DESIGN CERTIFICATE BY THE CONSULTANT

PROJECT: **RTS - Trinity Grammar School Renewal Project**
Prospect Road, Summer Hill, NSW, 2130

Request for Additional Information: 3(c) Maintenance Building on Seaview Street.

2808 DA308 Building Elevations-Seaview Maintenance C

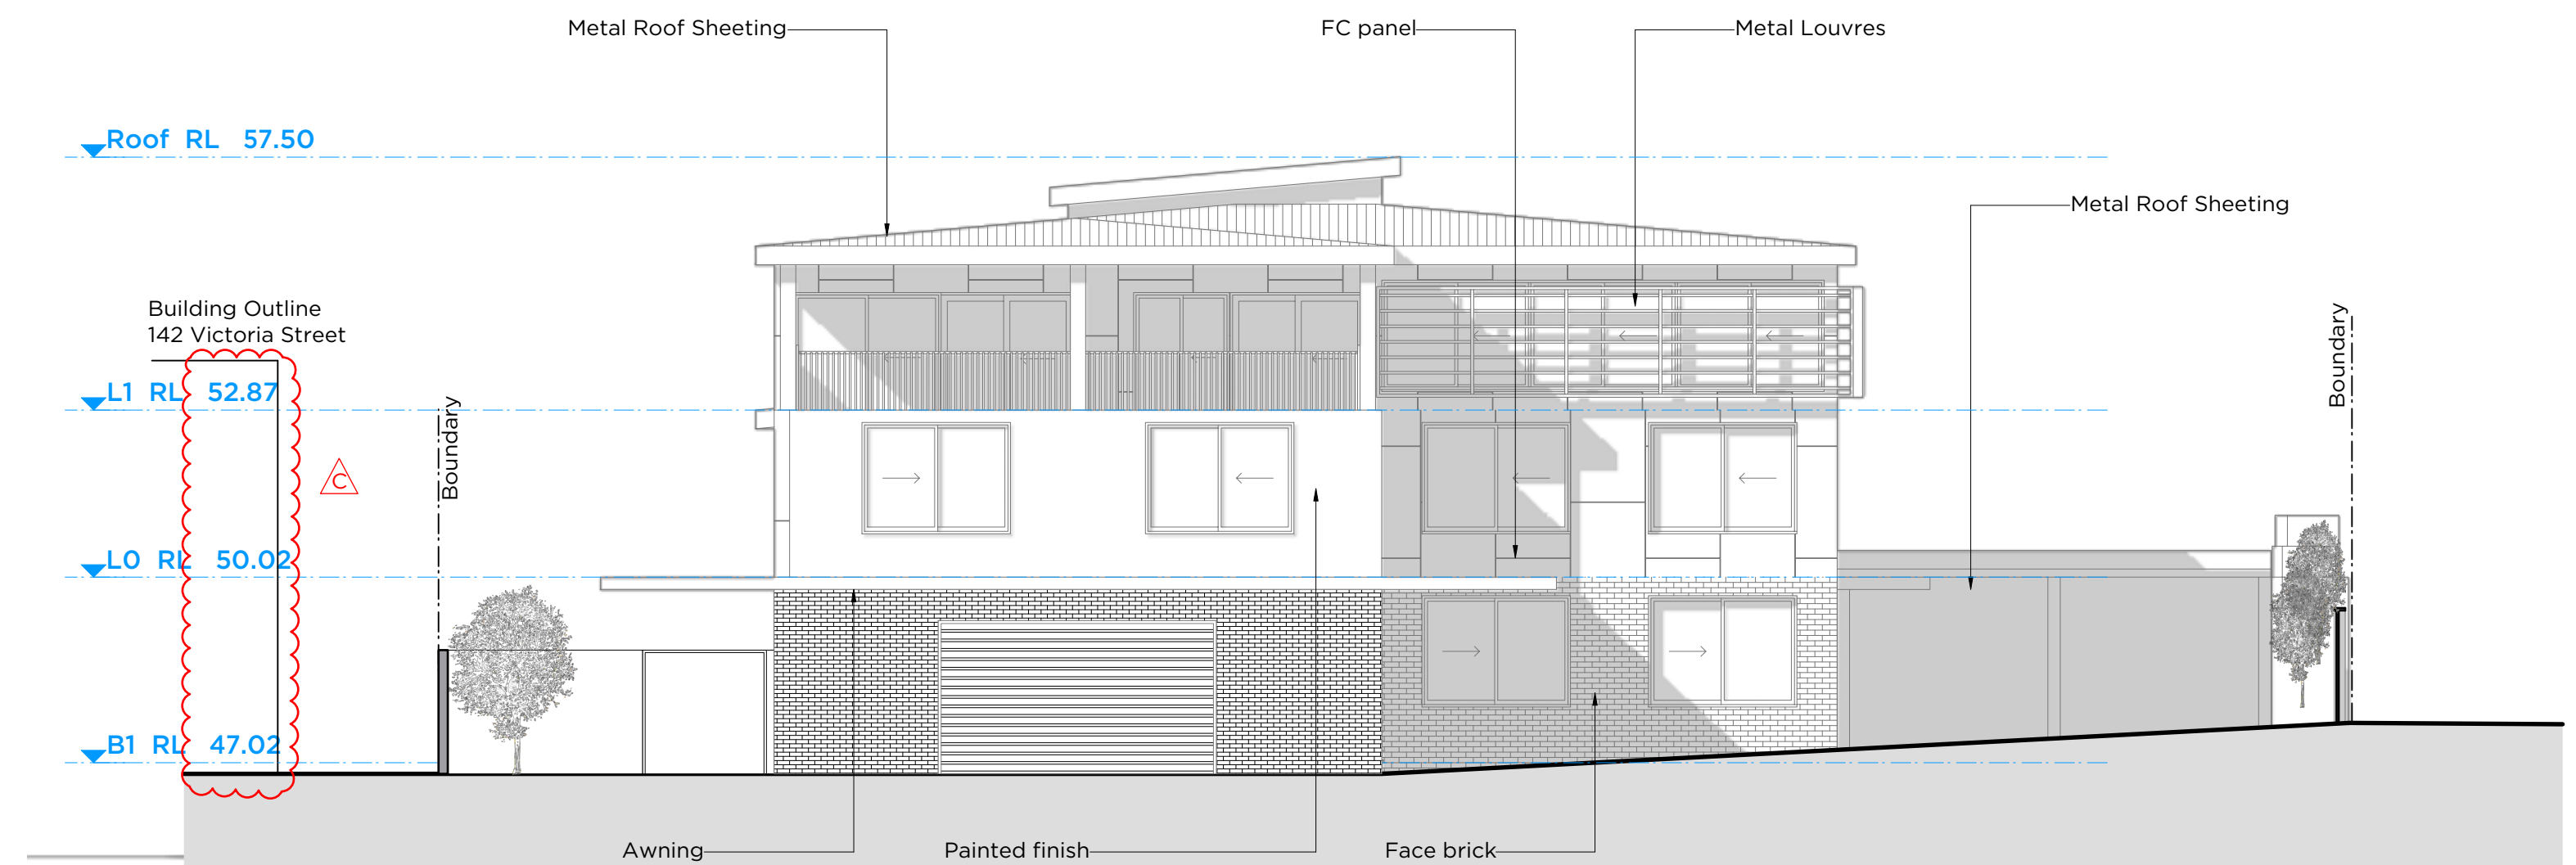
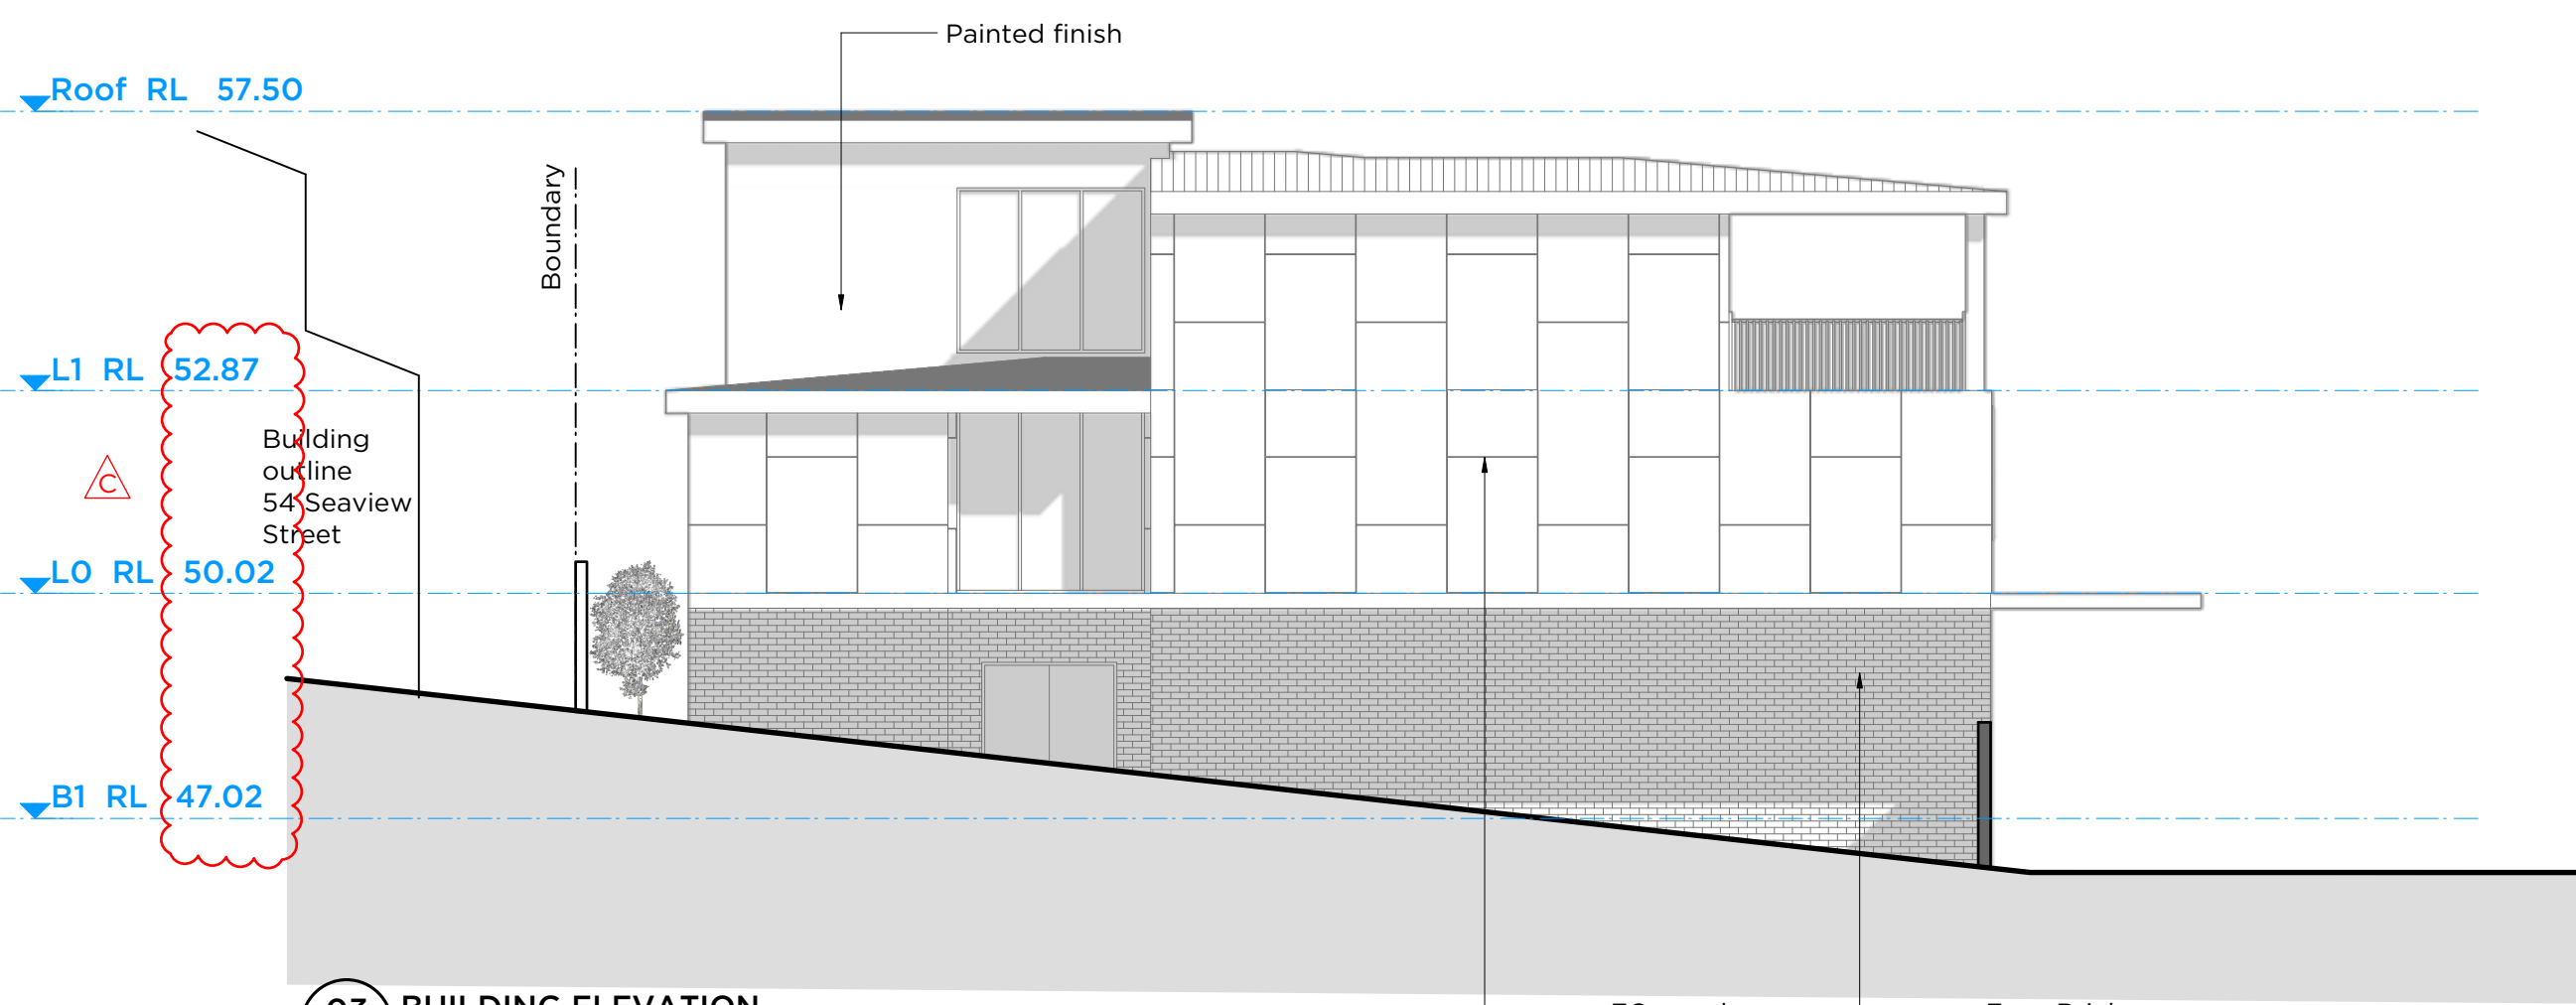
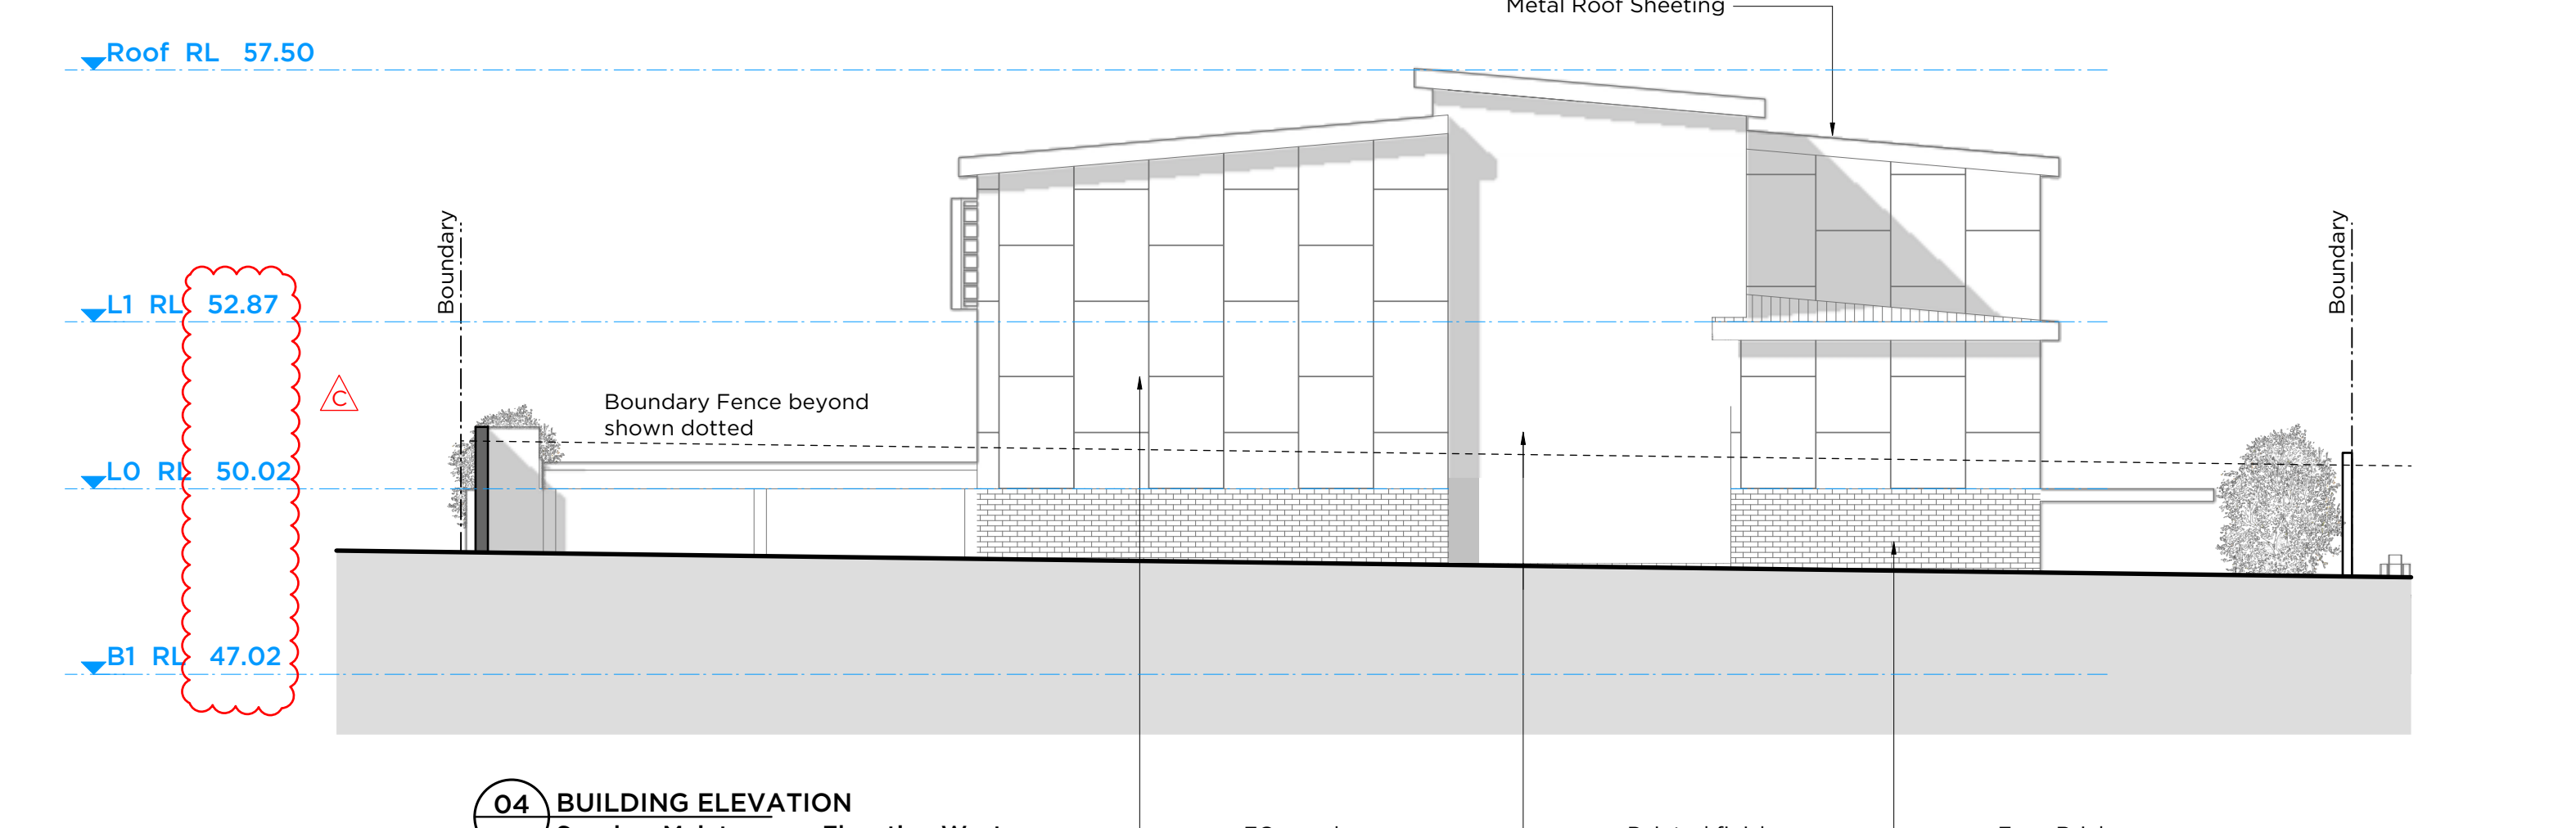
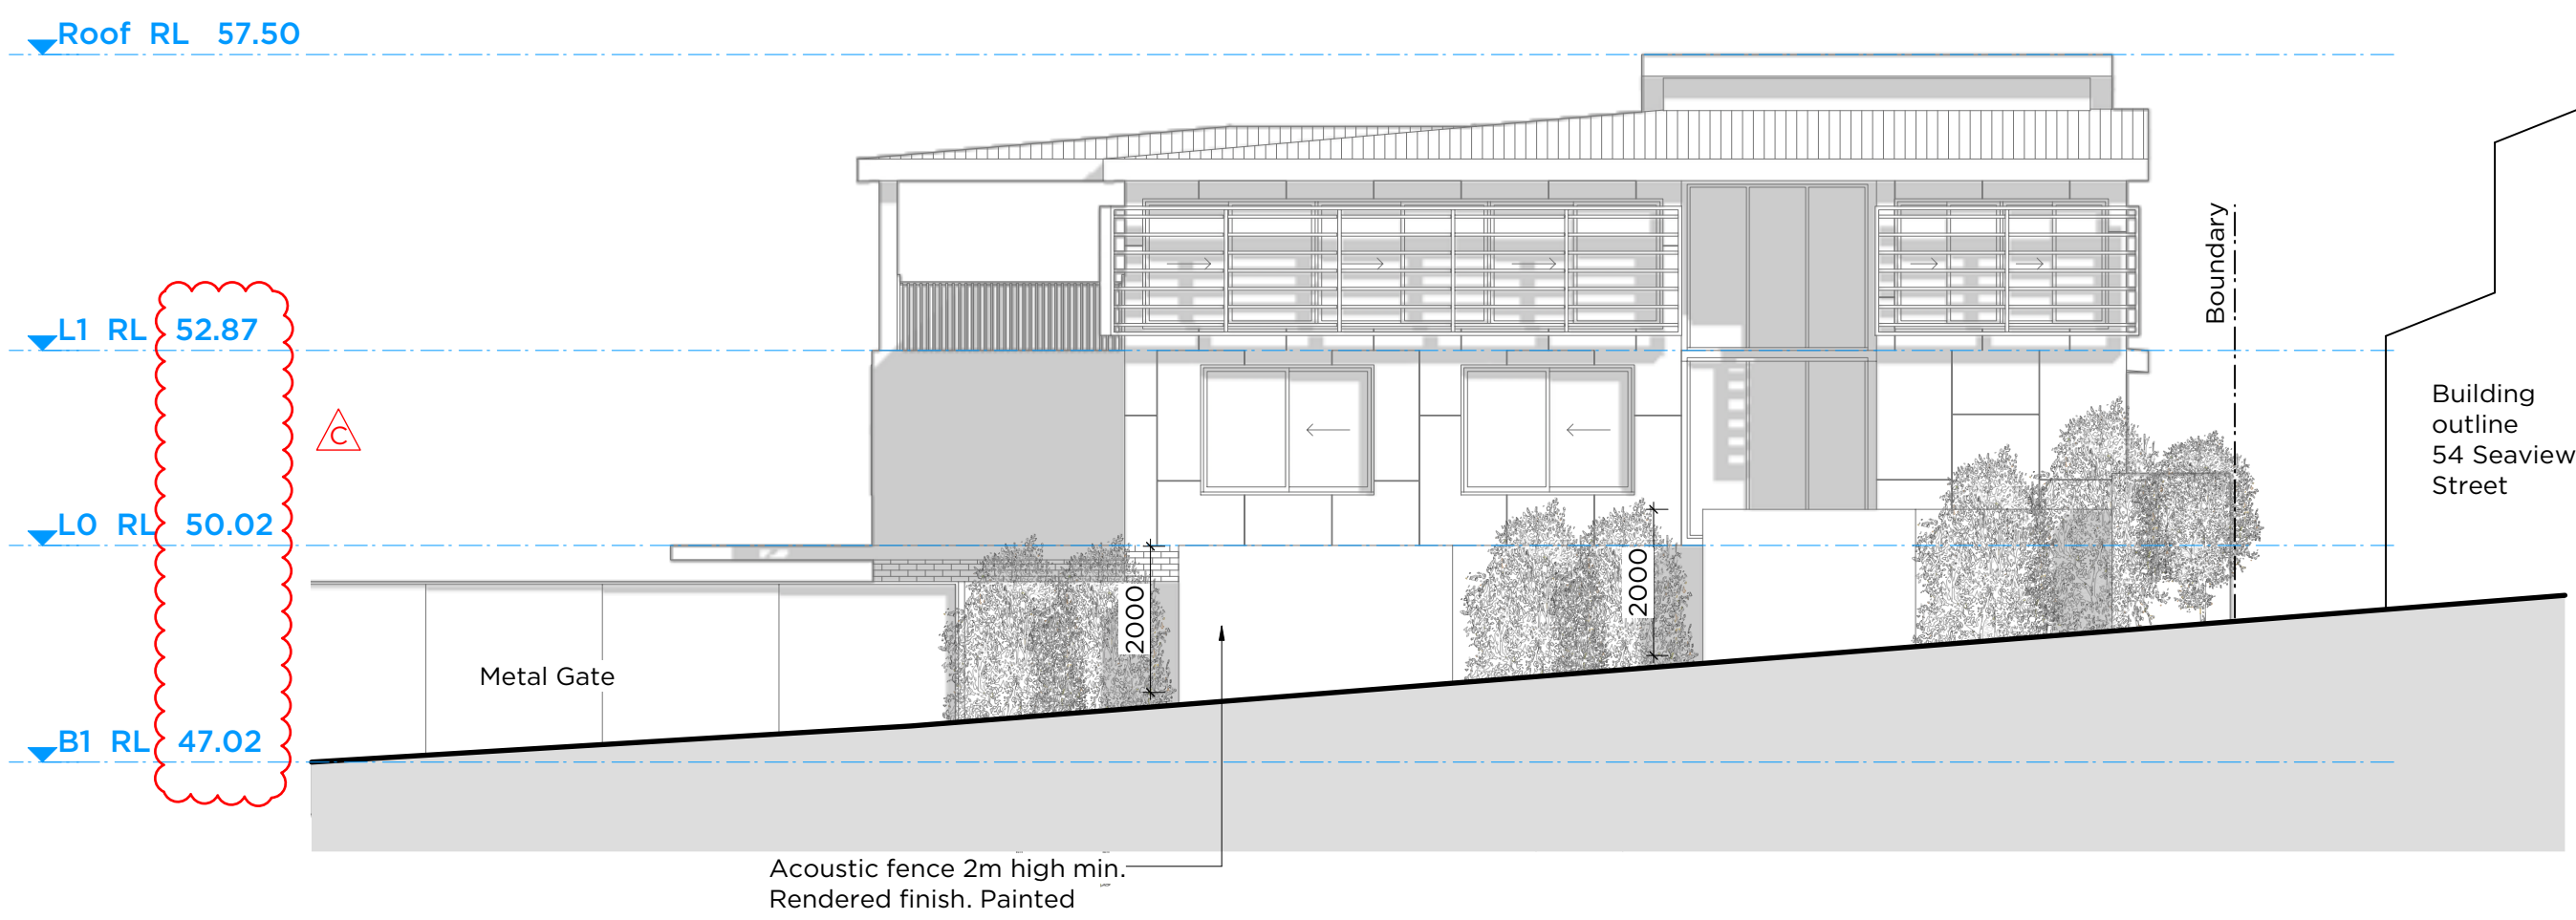
In response to the comment 3(c) – “The RtS requested elevations and details of plantings in front of the proposed Maintenance Building to screen its bulk from the street. The stepped boundary fence incorporates hedge plantings to the same height as the fence. While this helps to mitigate the streetscape impacts of the required acoustic wall it does not assist with screening the building. Given the non-compliance with the height control, further consideration should be given to providing plantings in the front” within the Trinity Grammar School Redevelopment (SSD-10371) Request for Additional Information.

The proposed plant species *Acmena Smithii* ‘Minor’ to screen the building and acoustic fence along Seaview Street will be planted in a hedge format with an unrestricted height of 5m in optimal conditions, with the maintenance of the plant species to be captured in the overall school maintenance regime. As the species proposed is commonly a screening plant, this allows for greater visual screening on mass assisting in visually separating the built form sight lines from Seaview Street.
